Clear out CBL# 185-B-8

permit# 03-0700

38 Hastings Street  
20' x 8' deck

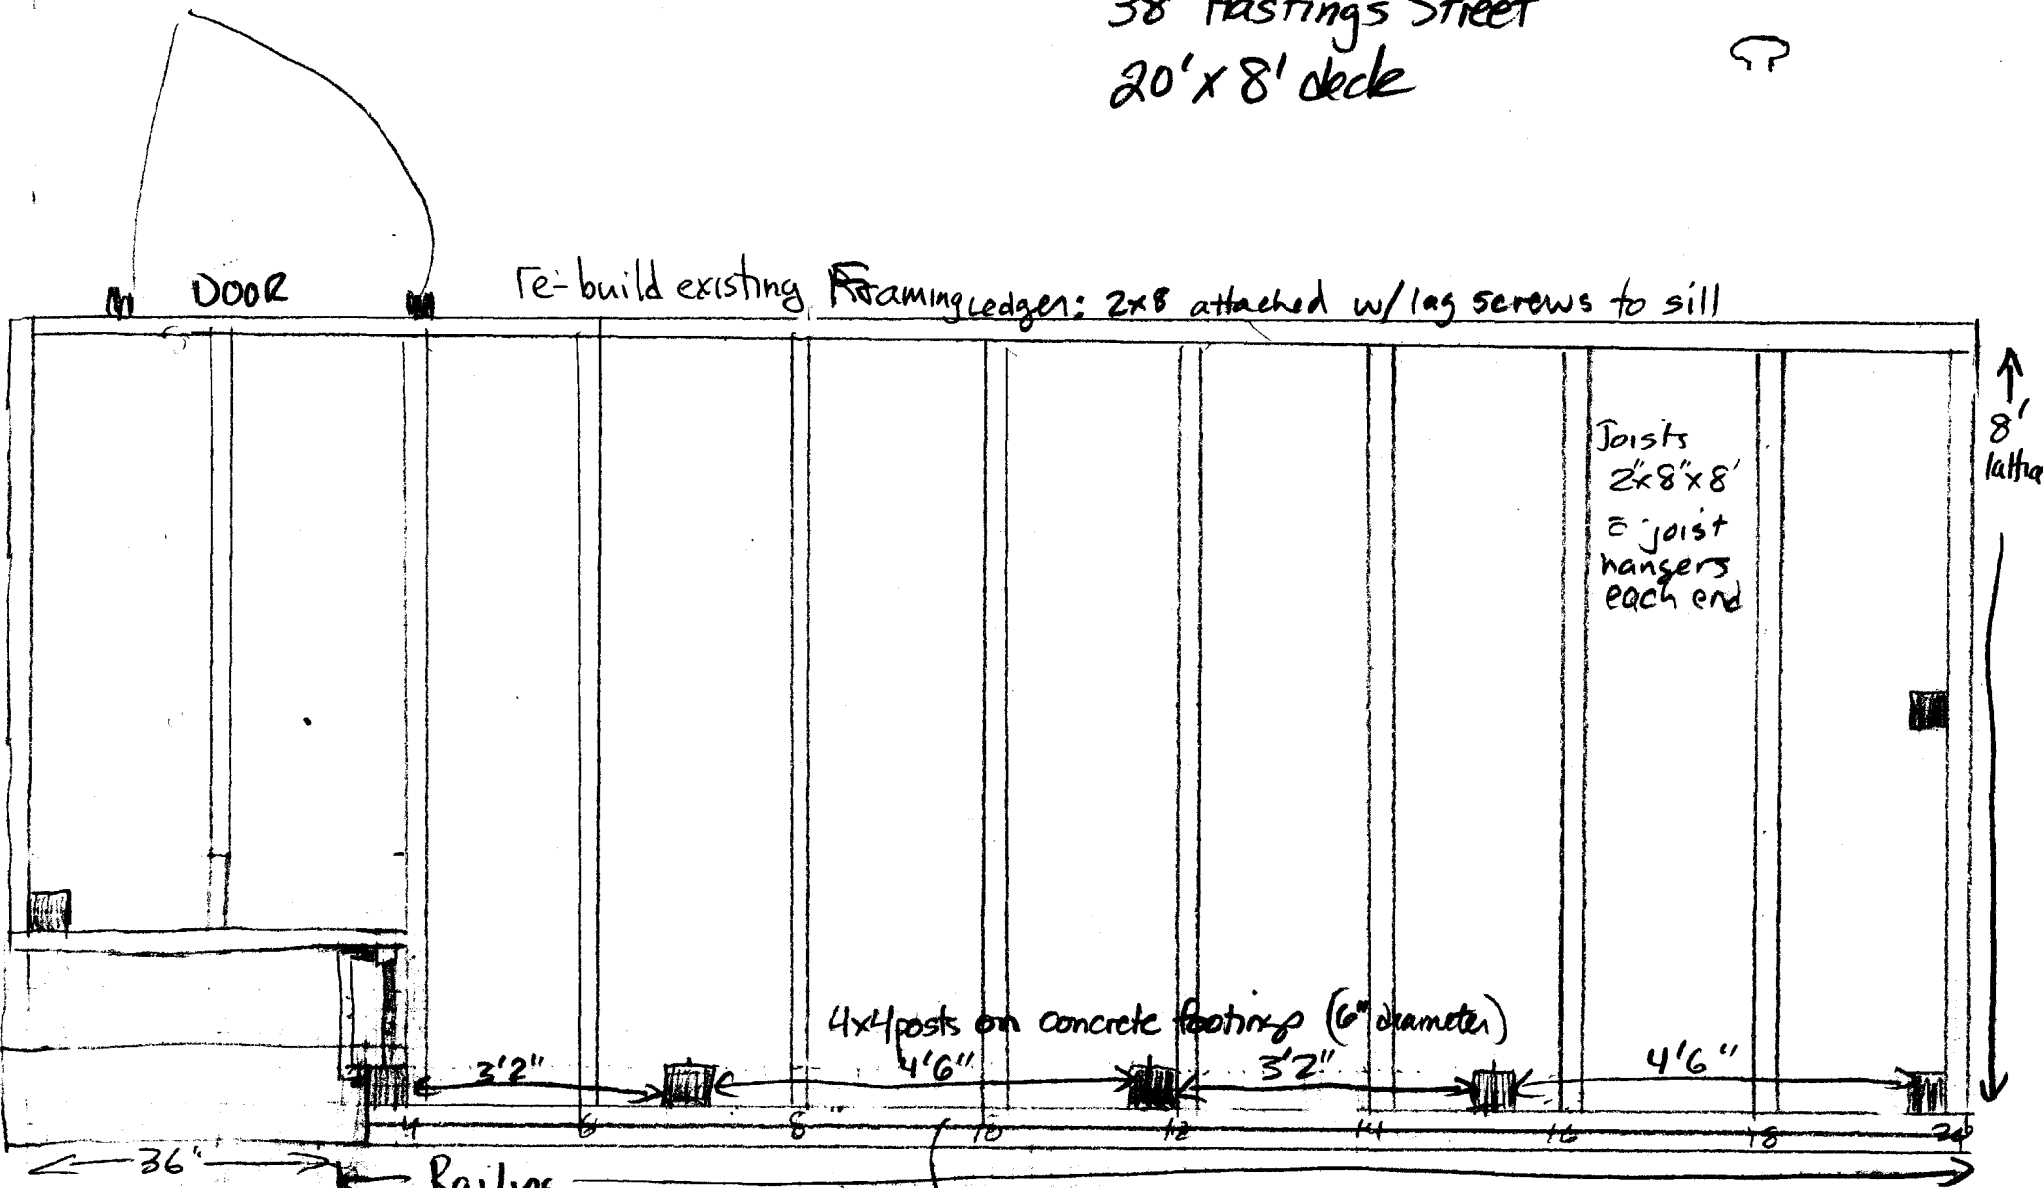
6/30/03 Inspected deck Framing - Stair stringers not
Installed yet. Utilizing existing guardrail & posts.
Some minor repair on existing non-conforming Rails JB

01/06/04 - heads OK - same footprint used - rails
same as old - no problems seen - setbacks
short on rear but is OK'd by reviewer (See 14-385)
16m
